DRB Project Case #: 1001946

OFFICIAL NOTICE OF DECISION

09DRB-70156 MAJOR – SITE DEVELOPMENT PLAN FOR BUILDING PERMIT

DRB Comments

DATE: 4/12/09
 SCALE: AS NOTED
A1.0

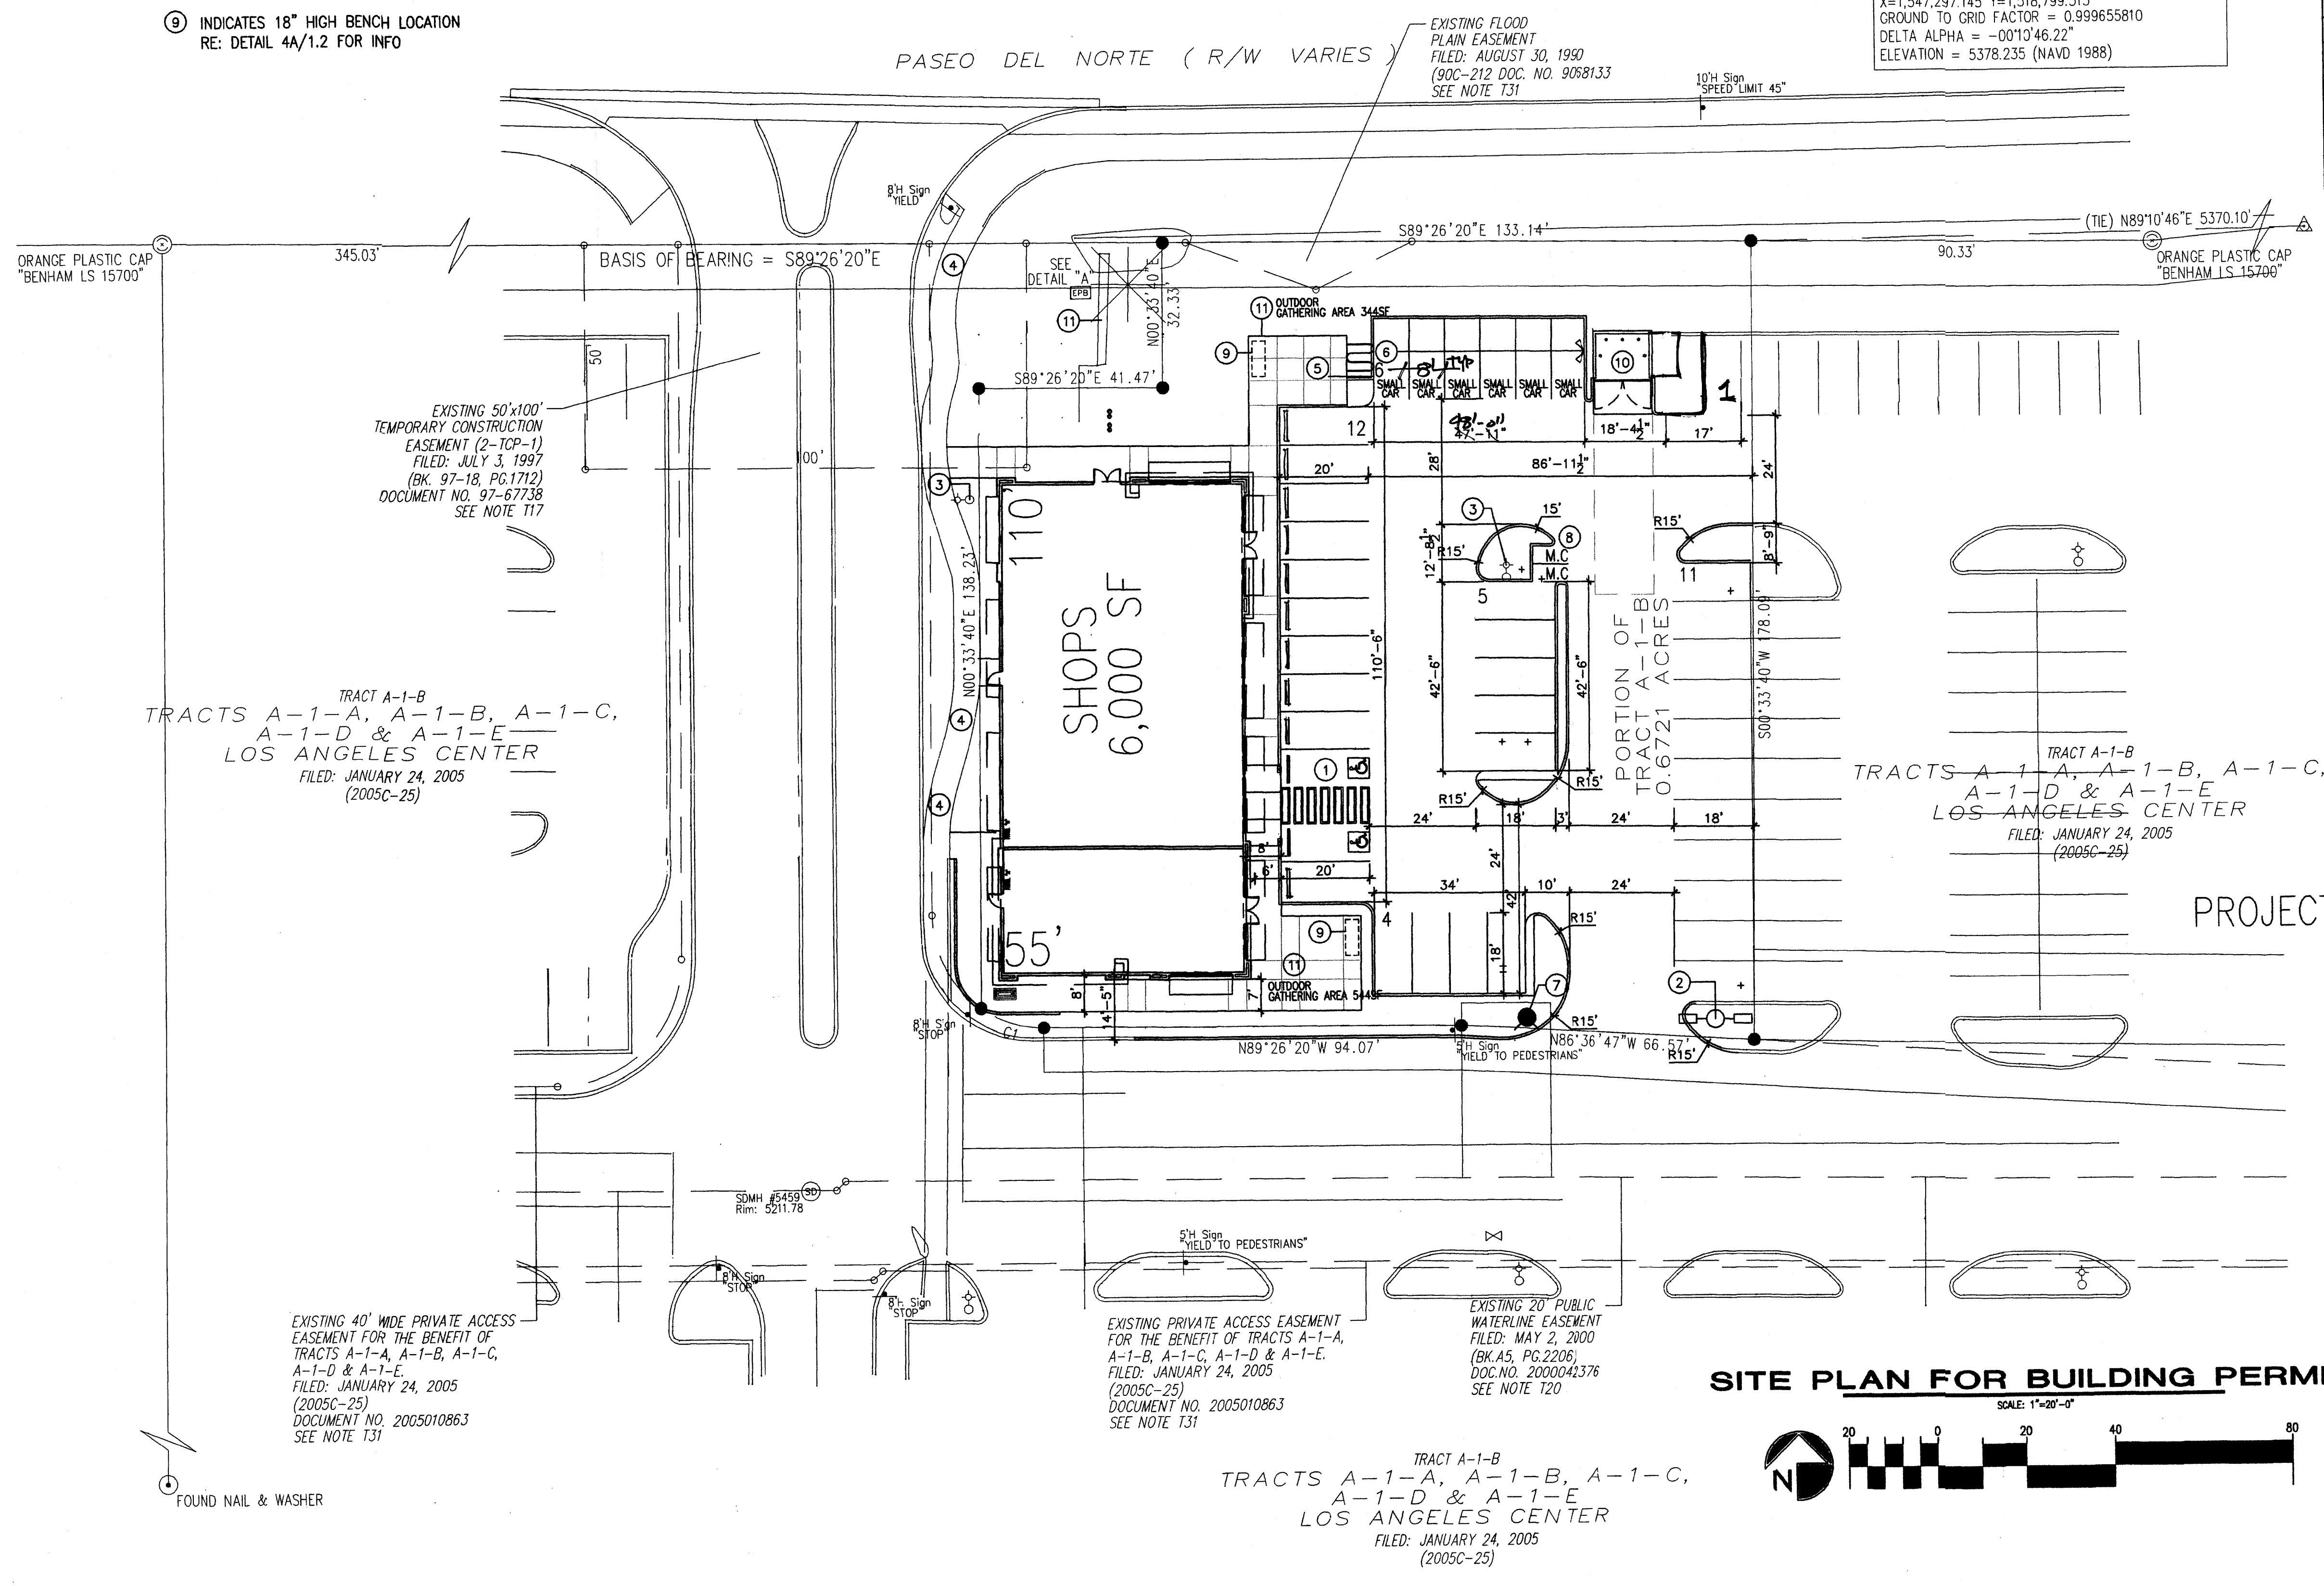
Parking calculations are needed Lowe's Shopping Center to demonstrate that this site constitutes excess parking.

The proposed modifications remove the anticipated alignment between parking aisles in the southwest corner of the site. How will this be remedied?

Clarify existing versus proposed conditions.

Call out all radii.

Define all geometric data (aisle width, sidewalk width, parking stall measurements, etc.).

Compact parking stalls must be 8 feet in width.

- 1) all sheets of the site plan shall be consistent (i.e. show the same plan features, particularly curbing)
- 2) Compact Parking Spaces shall be noted and shown as 8 feet in width
- 3) parking calculations shall demonstrate adequate parking for the Shopping Center
- 4) the north and west elevations of the building shall be approved by the Planning Director, based on their orientation to a principal arterial and the main entrance to the Shopping Center.
- 5) sign area calculations shall demonstrate compliance with the signage guidelines of the Site Development Plan for Subdivision.

2 WESTERN ELEV.

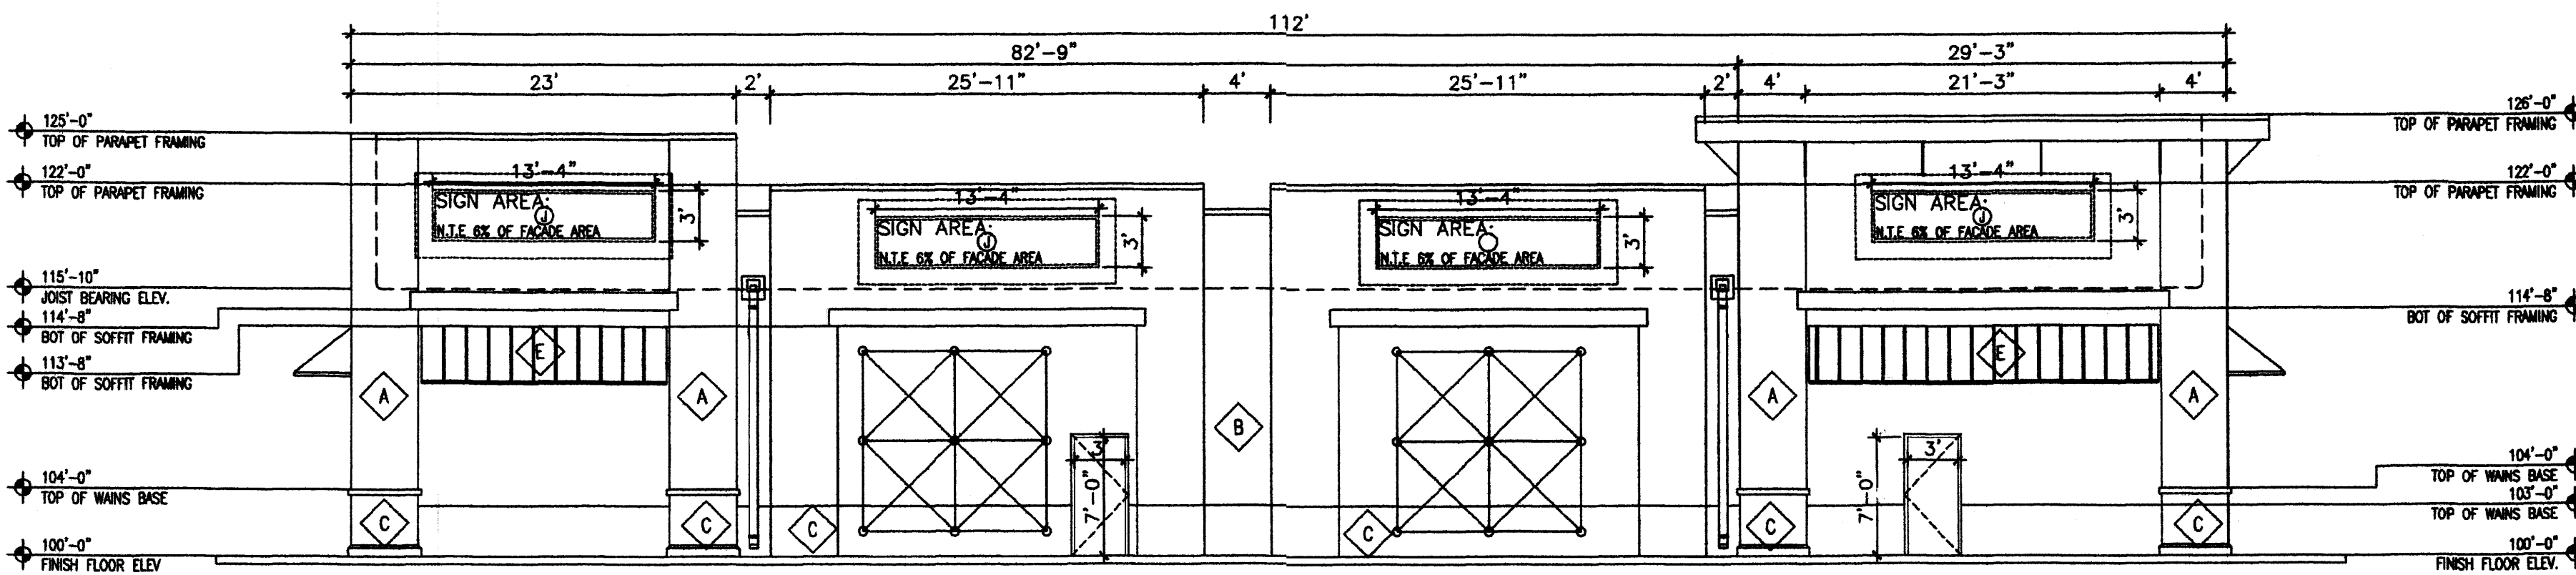
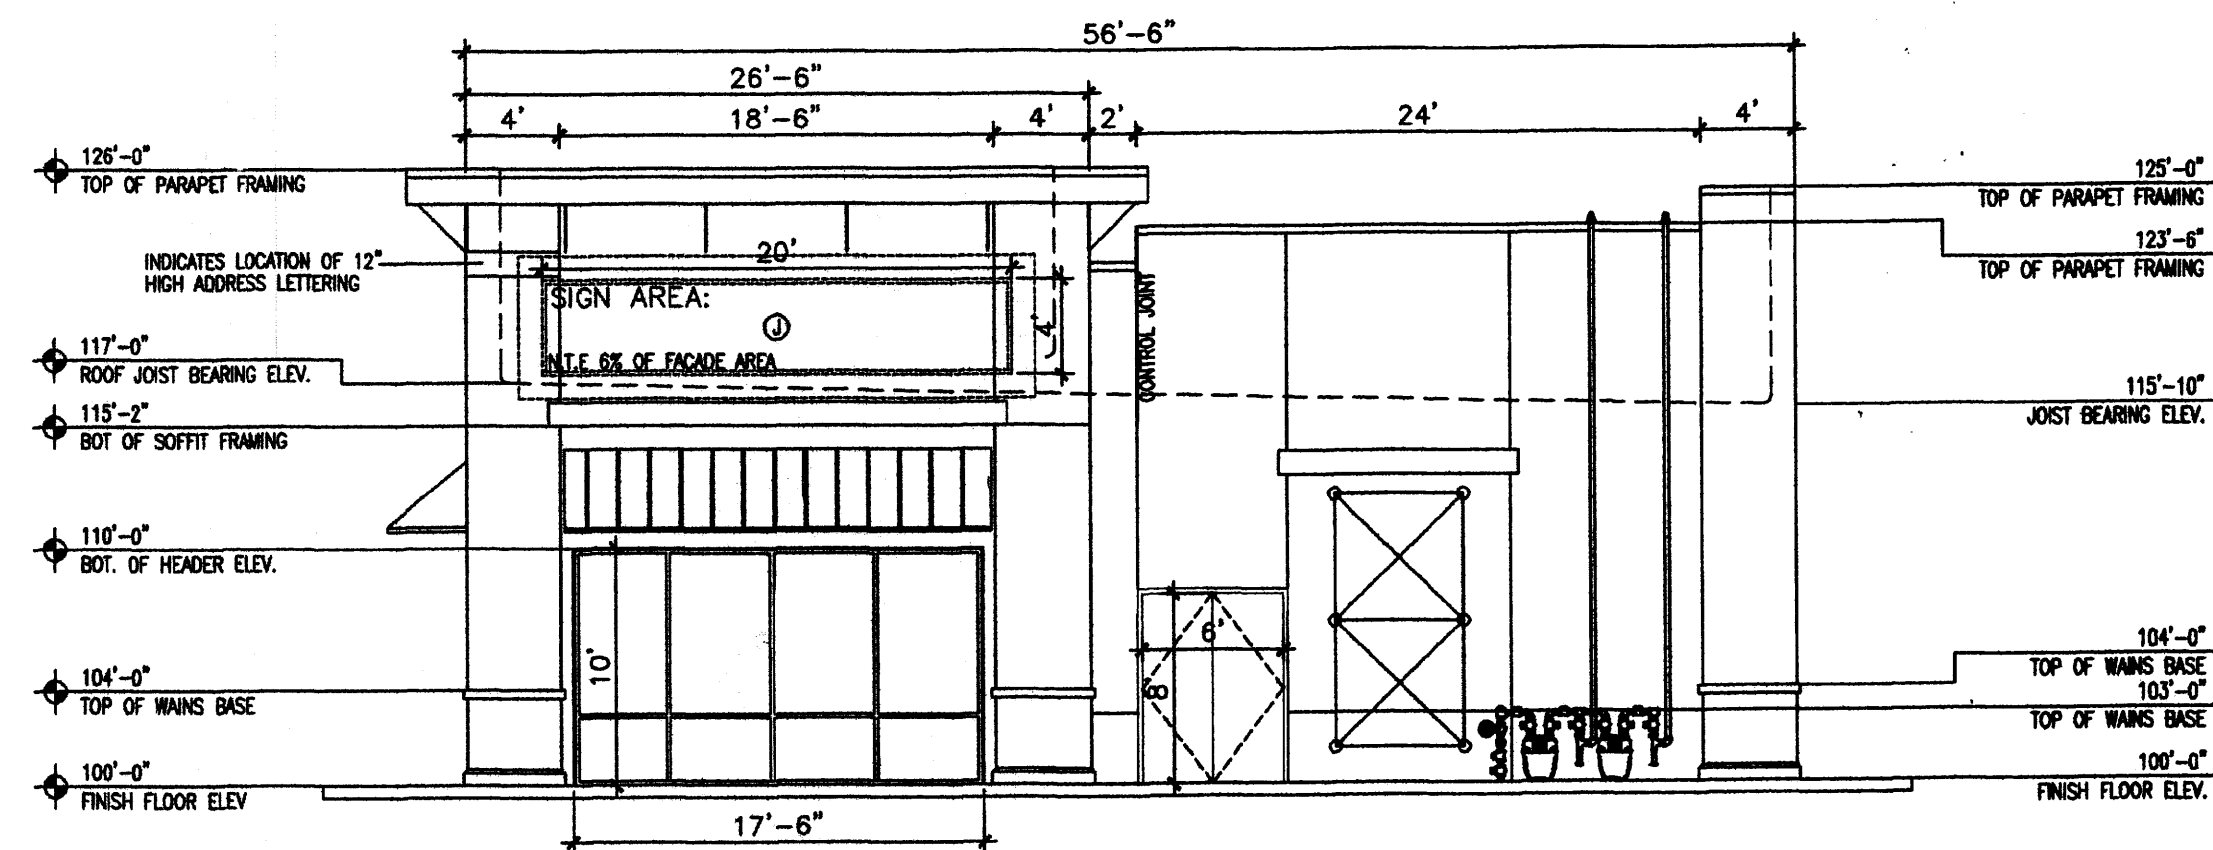
Canopies need to be provided on all segments on the north and west elevations of the building.

Proposed sign areas exceed the signage guidelines of the Site Development Plan for Subdivision – these sign areas need to be drawn in compliance with the guidelines.
